**From:** Thomas Whitfield <thomas@georgiangroup.org.uk>  
**Sent:** 24 September 2025 08:01  
**To:** DC Admin  
**Cc:** Conservation Design  
**Subject:** Case 2025/92388 - Red House Museum, 281 Oxford Road, Gomersal

Thank you for notifying The Georgian Group of application 2025/92388 for a scheme of works to convert The Red House Museum, 281 Oxford Road, Gomersal from 3no. residential units. The Group registers no objection in principle to the conversion however we raise the following concerns with the proposed scheme of works.

The application is for a scheme of internal and external works to convert the house to form 2no. residential units and the barn to 1no. residential unit.

Barn
Ground & First Floor Plans as Proposed

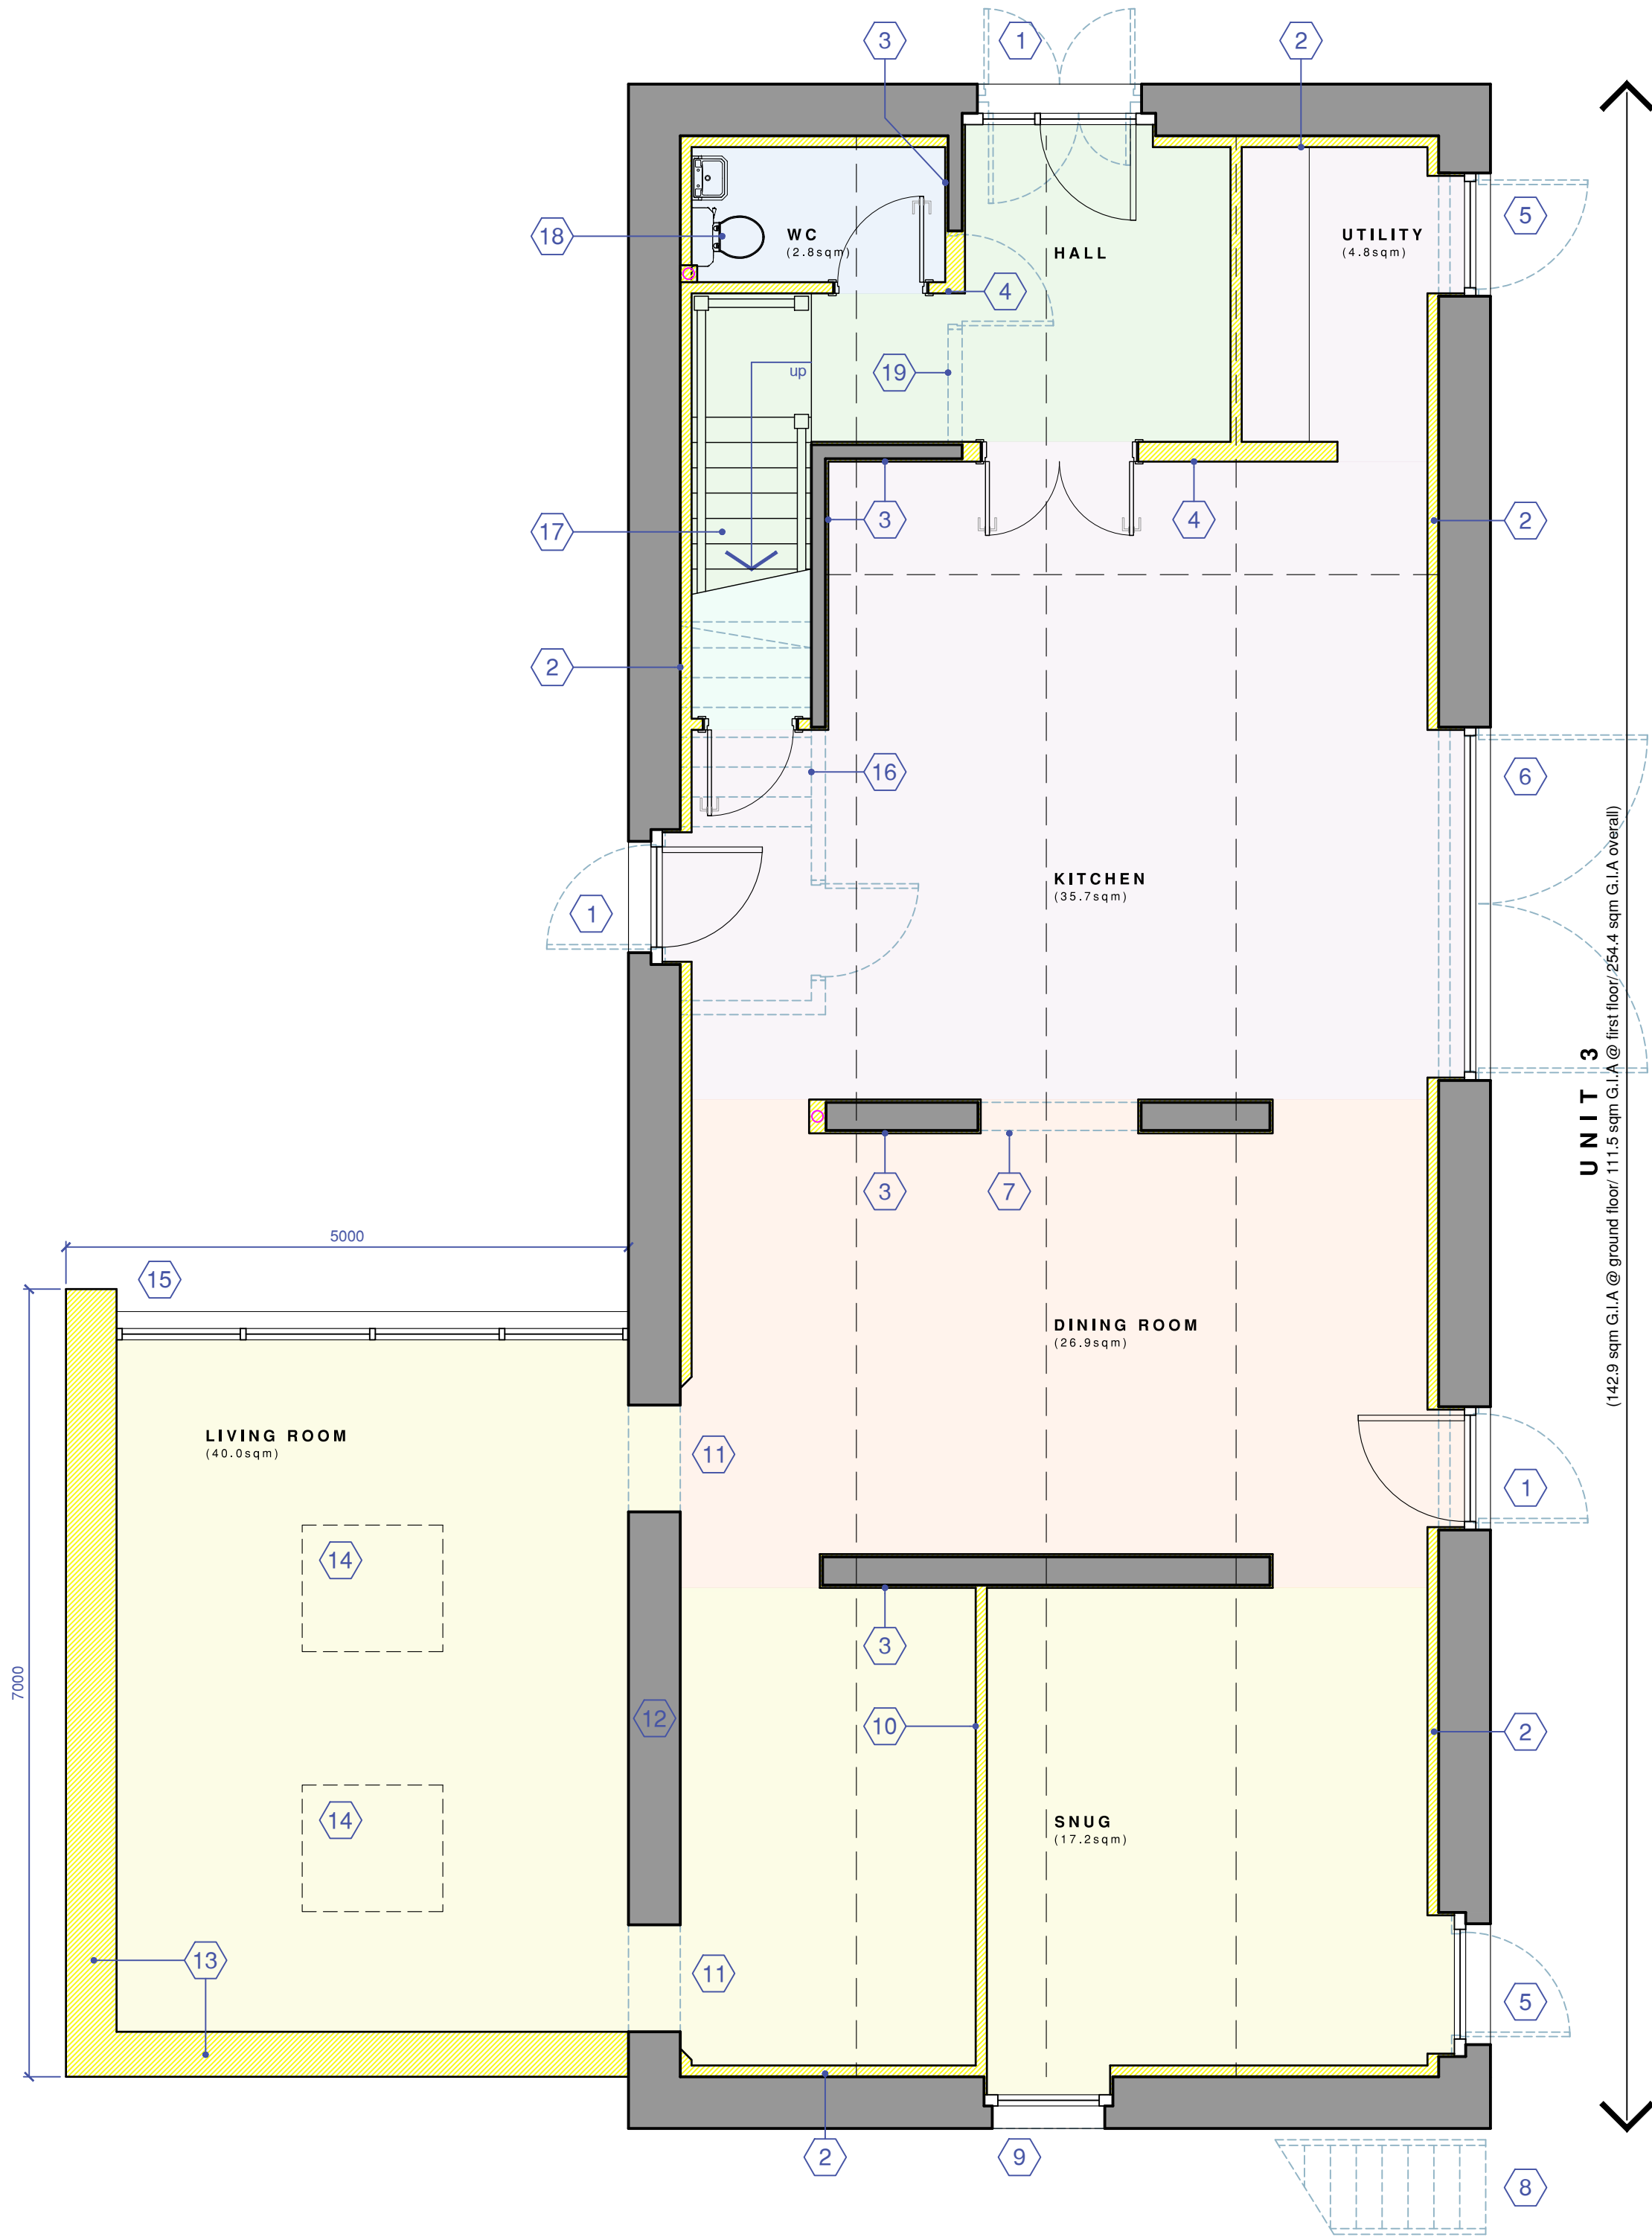
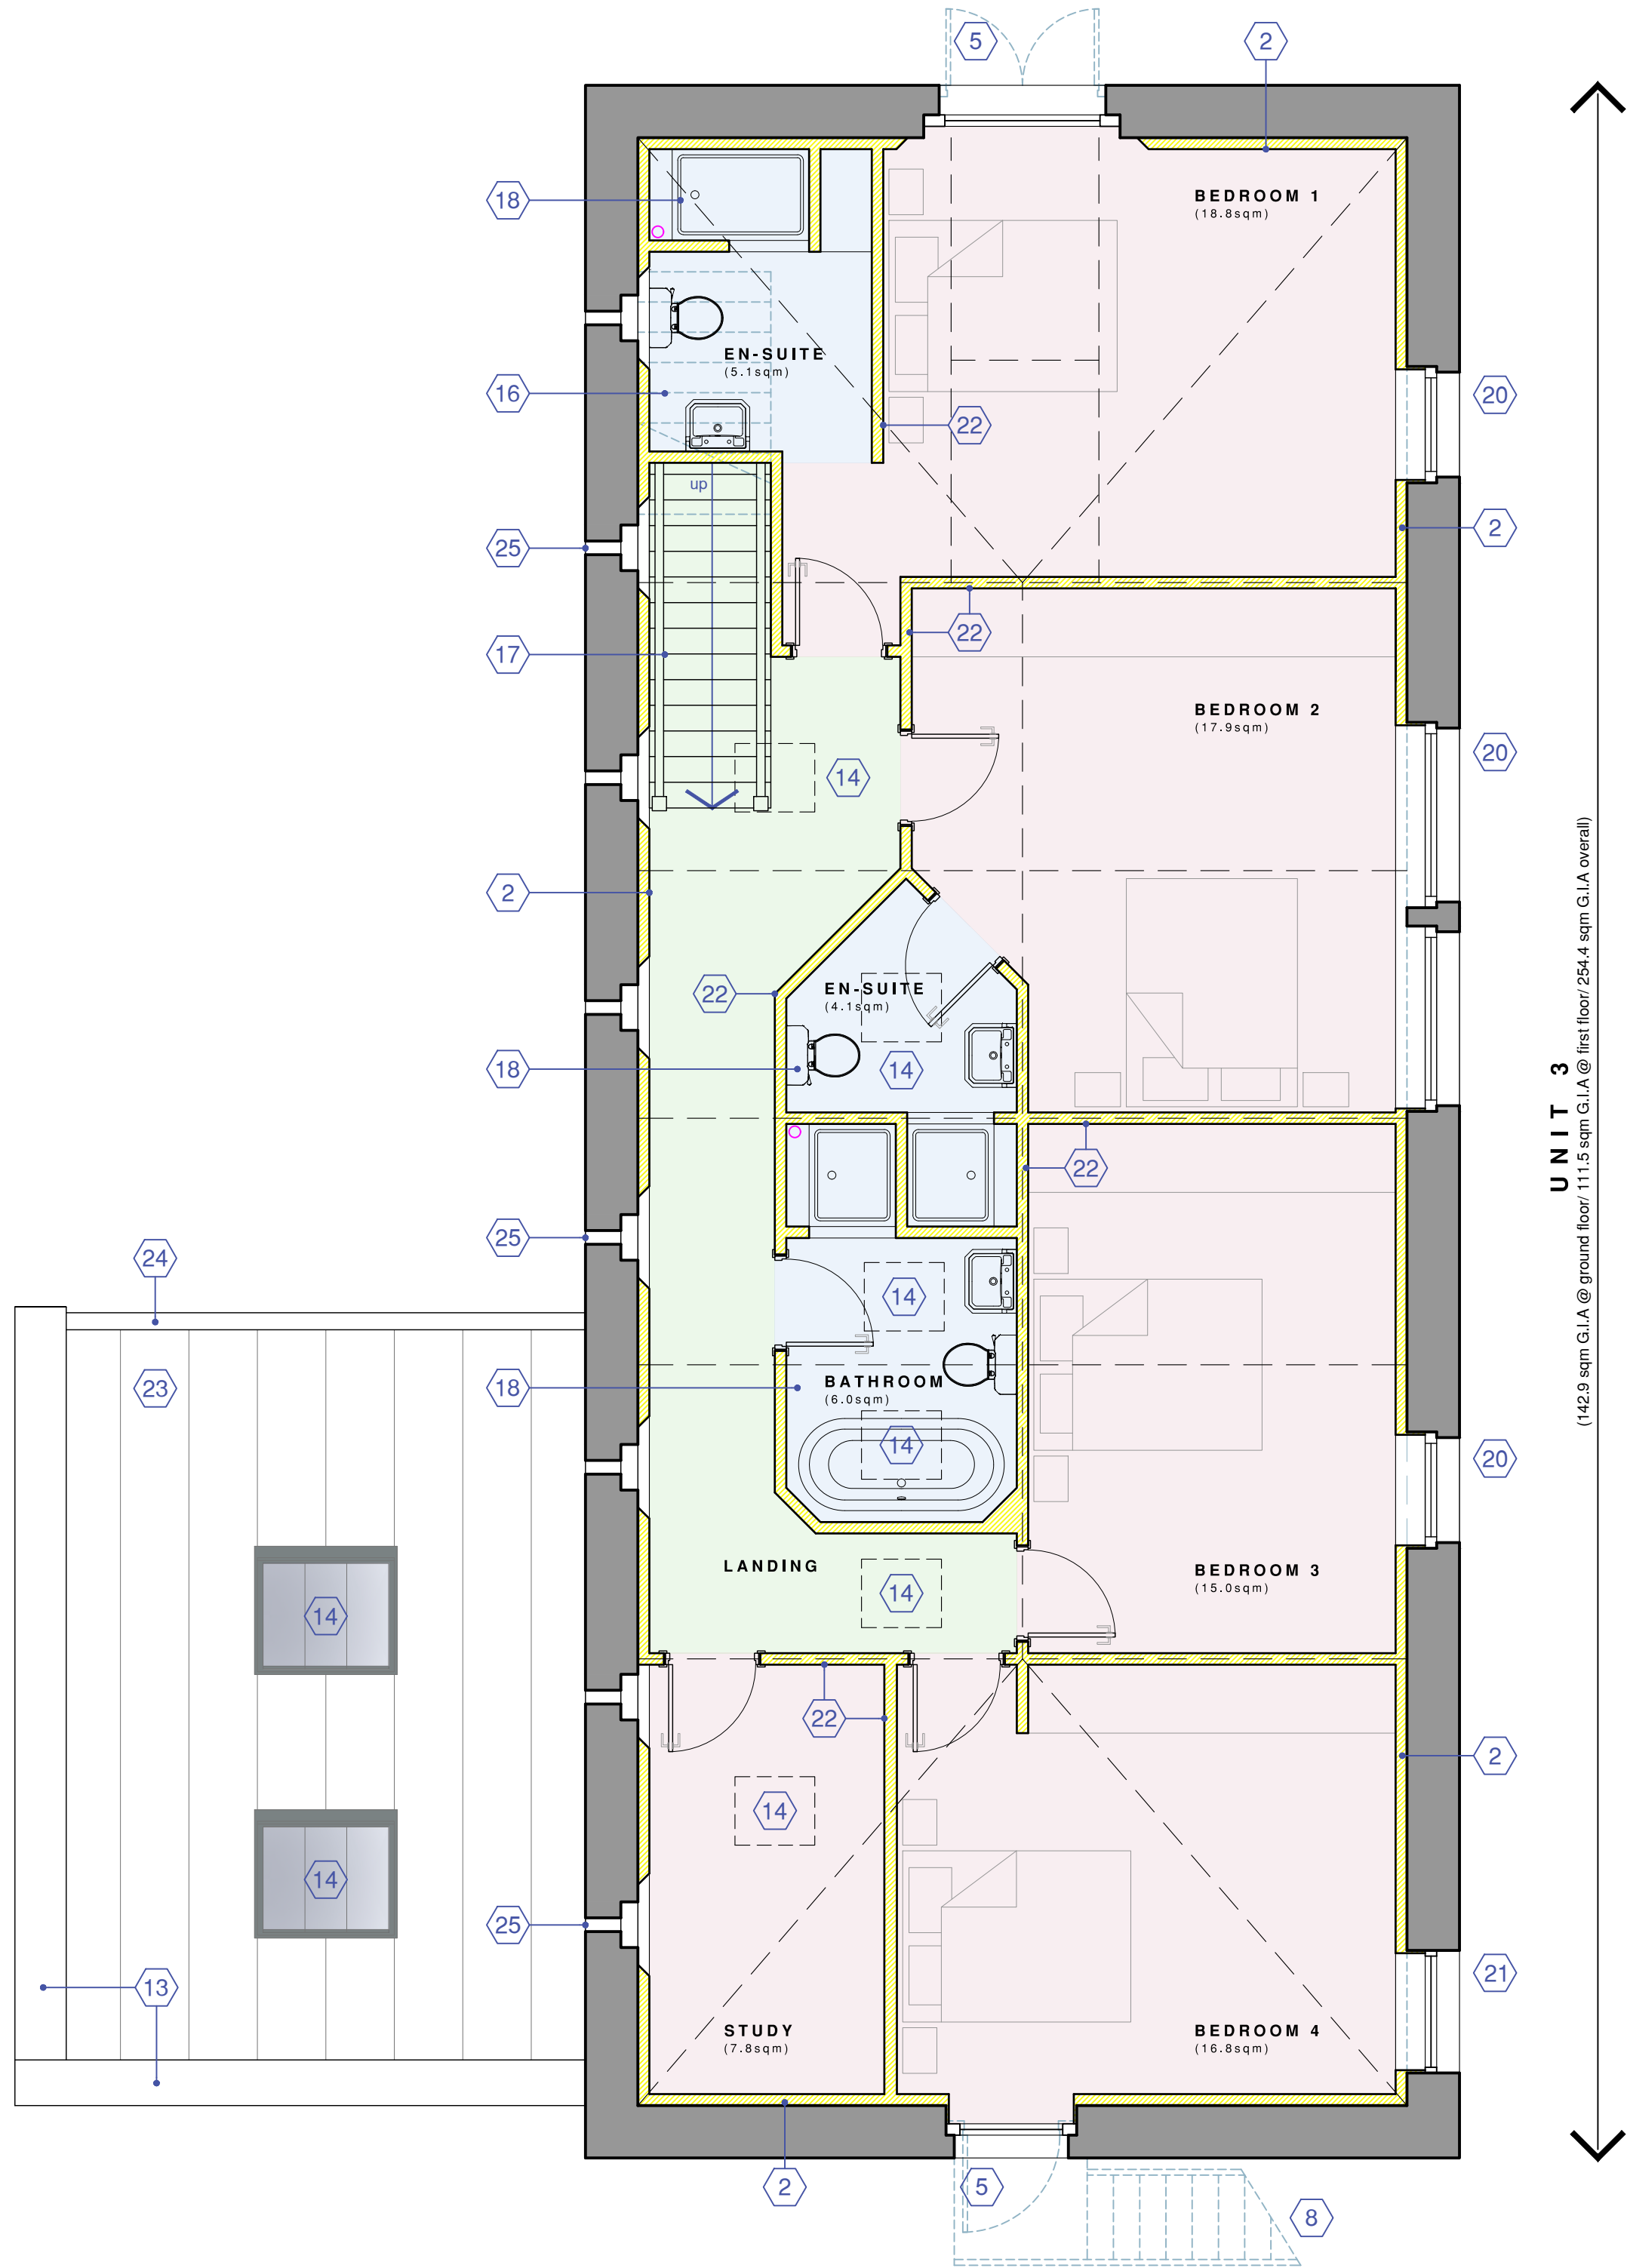
The Group registers concerns with the proposed intensive subdivision of the first floor. The first-floor space was historically an open plan room to allow for cloth inspection and finishing. The extent of subdivision proposed, however, severely erodes the legibility of this historic function, creating a highly cellular arrangement which is quite at odds with the historic layout. Whilst we recognise that there will need to be some division at 1F level, we recommend that this is minimised as far as possible.

We particularly advise that the proposed bathroom and ensuite in the centre of the first floor are especially incongruous and disruptive to the legibility of the historic open planform and do not give the due great weight to the asset's conservation as required under NPPF paragraph 212.

We furthermore advise that it is not clearly justified why the building requires 2no. ensuites and a family bathroom at 1F, plus a w/c at GF level (total 4no. toilets) to serve 4no. bedrooms. We advise that we do not consider that this is justified under the terms of NPPF paragraph 213.

We strongly recommend that the applicant explores alternative arrangements whereby either the number of proposed bathrooms is reduced, or the proposed bathroom facilities could be less intrusively accommodated elsewhere, perhaps a family bathroom instead of the proposed study.

We likewise advise that the subdivision of the southern room at GF level to create a snug and corridor is an inefficient use of space creating a dark internal room. We furthermore raise concerns that it is proposed to form 2no. new openings in the historic rear elevation. It is however not clearly explained or justified why 2no. elevations are needed, and we advise that having 2no. openings will only serve to make the corridor [subdivided from the snug] an even less used space.

We recommend that the applicant revises the proposals to investigate alternative planforms which better support and are more sympathetic to the significance of the barn as a listed building. We recommend that if an extension is to be considered necessary it should work harder to reduce the need for harmful and intrusive alterations within the listed barn.
